Rezoning Transportation Analysis

Petition Number: 2023-047

Date	Description
8-24-23	First Review (IW)
11-21-23	Second Review (IW)
01-24-24	Third Review (KC)
02-26-24	Trip Generation Update (DR)

SHEET NUMBER:
RZ-2

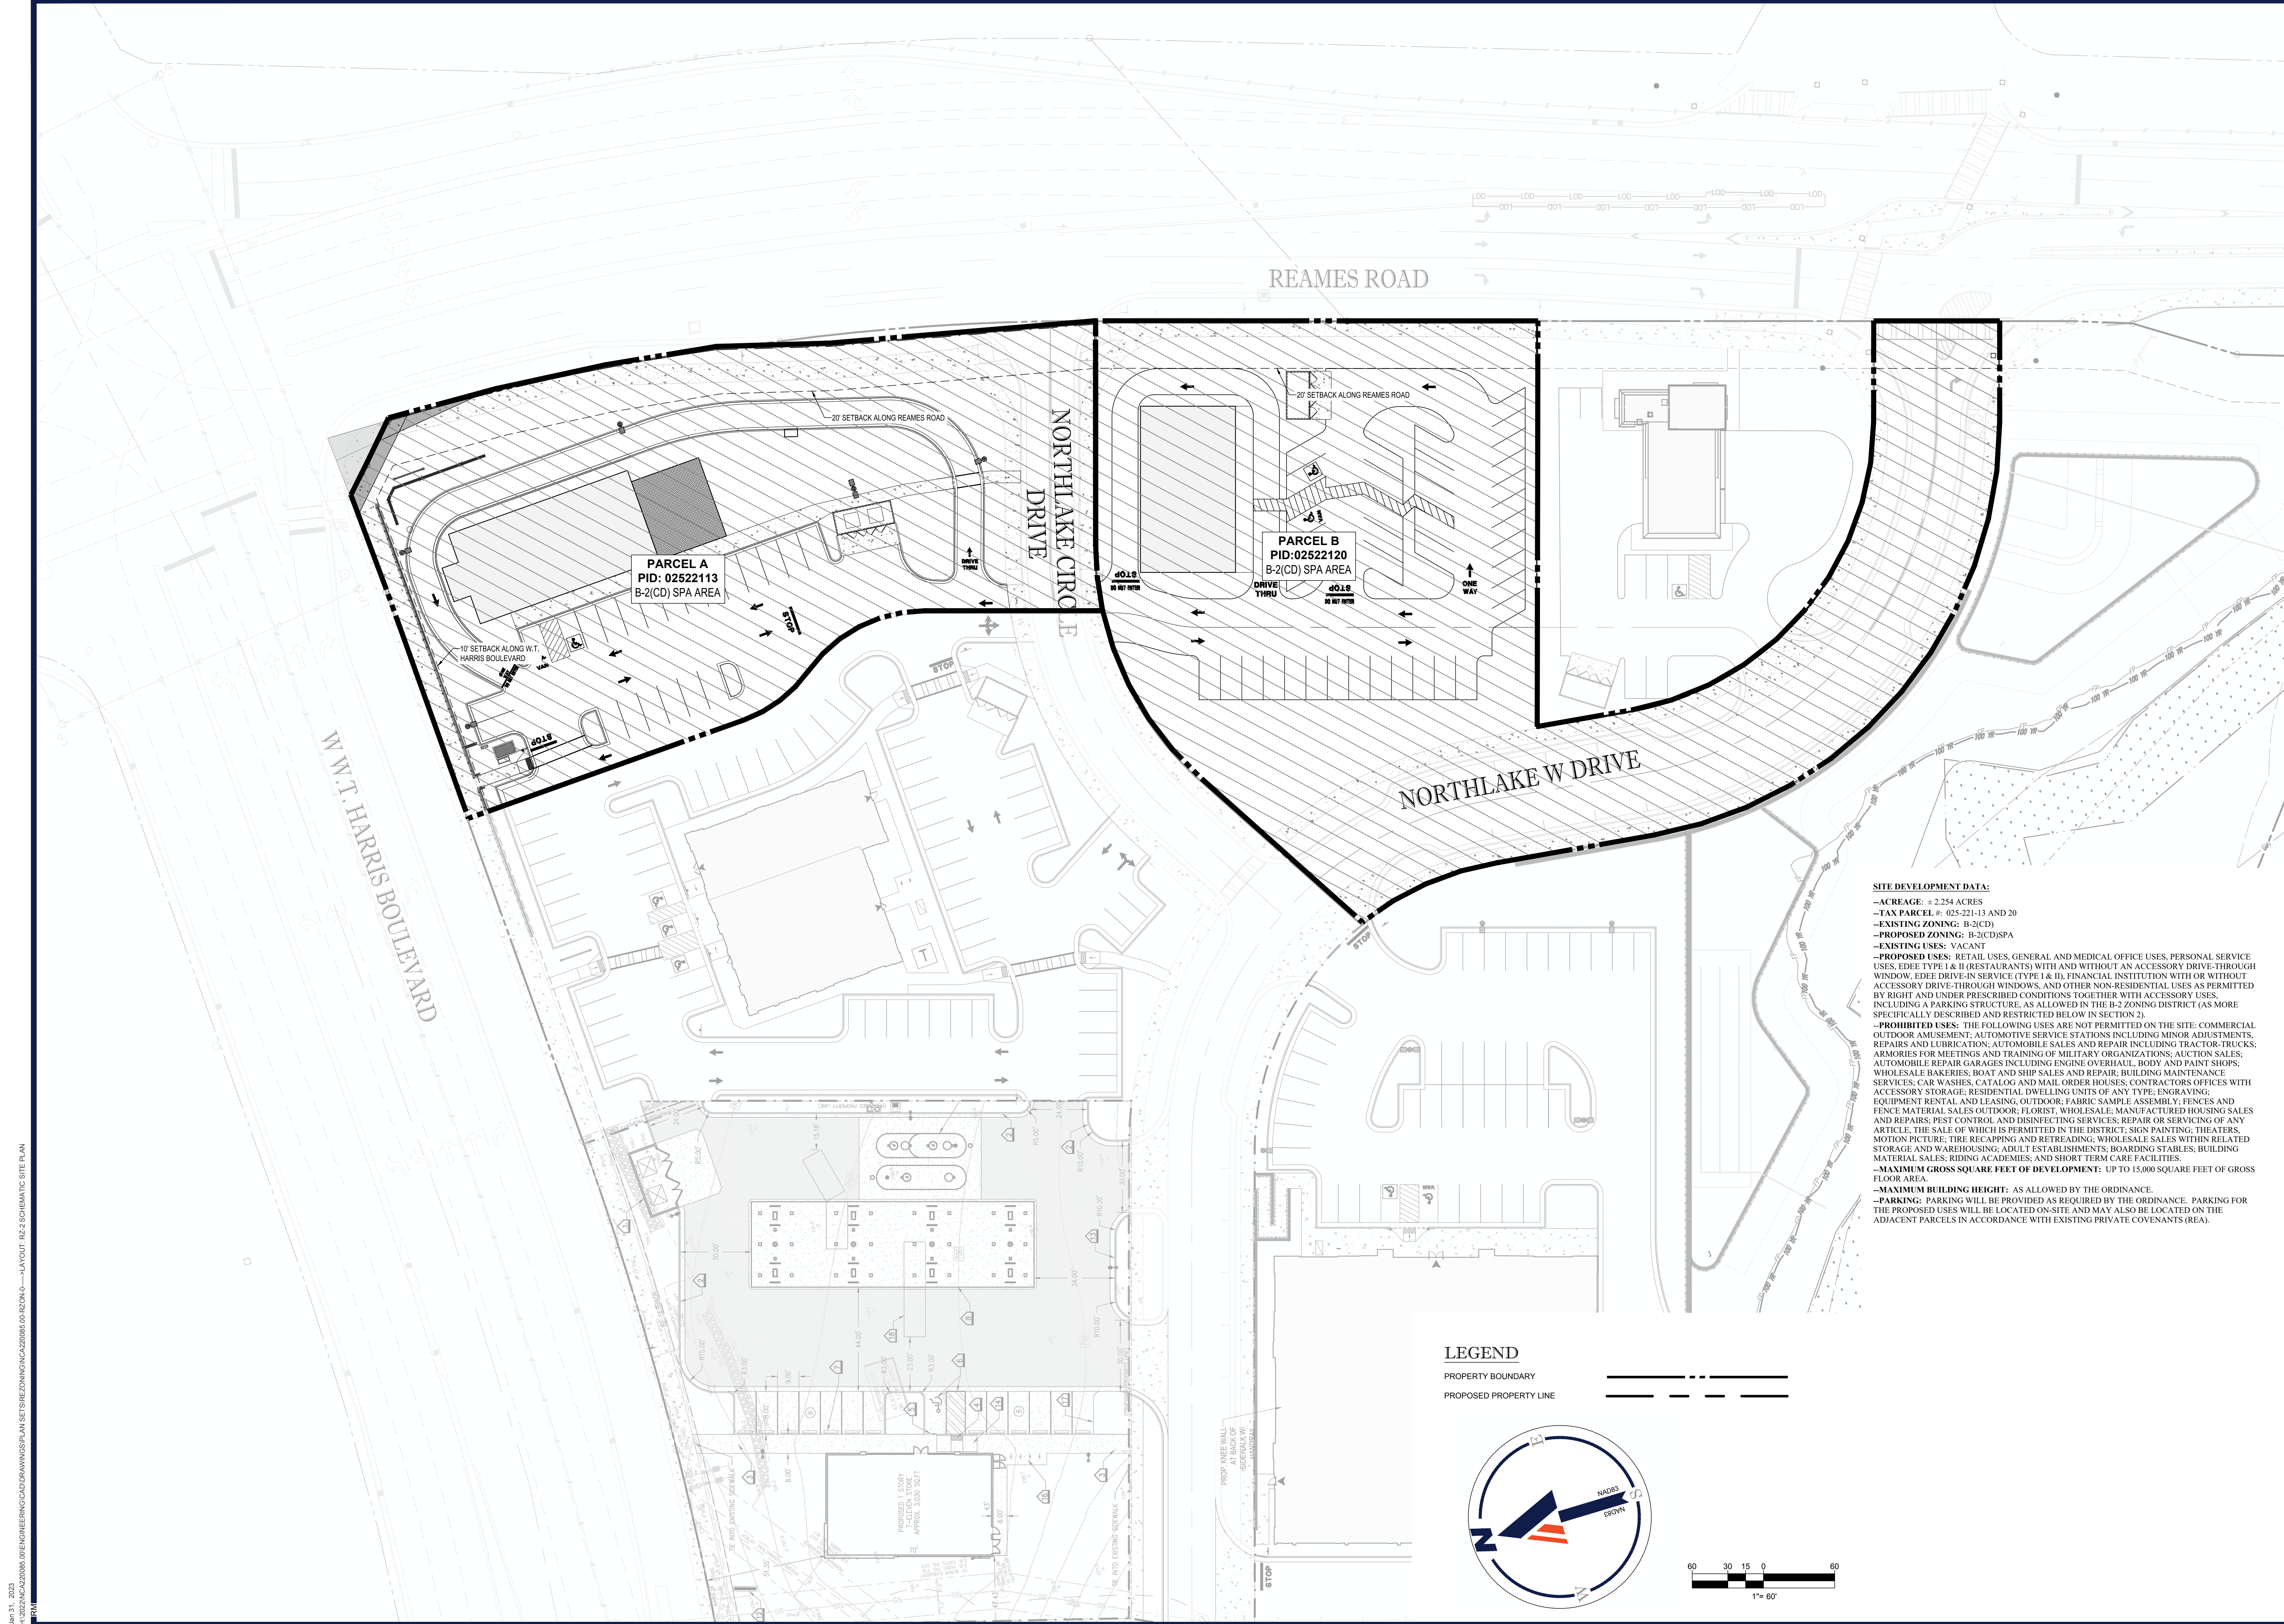
- a. ~~W T Harris Blvd:~~ Location of future back of curb and gutter to be 44 feet from roadway centerline to accommodate the Charlotte Streets Map with a roadway typical section of 6+ Boulevard, Shared Use Path.
- b. ~~Reames Road:~~ Location of future back of curb and gutter to be moved to 38 feet from roadway centerline to accommodate the Charlotte Streets Map with a roadway typical section of 4+ Avenue, Buffered/Separated Bike Lanes.

Label and dimension the curb and gutter from the centerline for each road on the site plan.

Clarifying Comment: Site plan needs to Label and dimension the curb and gutter from the centerline for each road on the site plan.
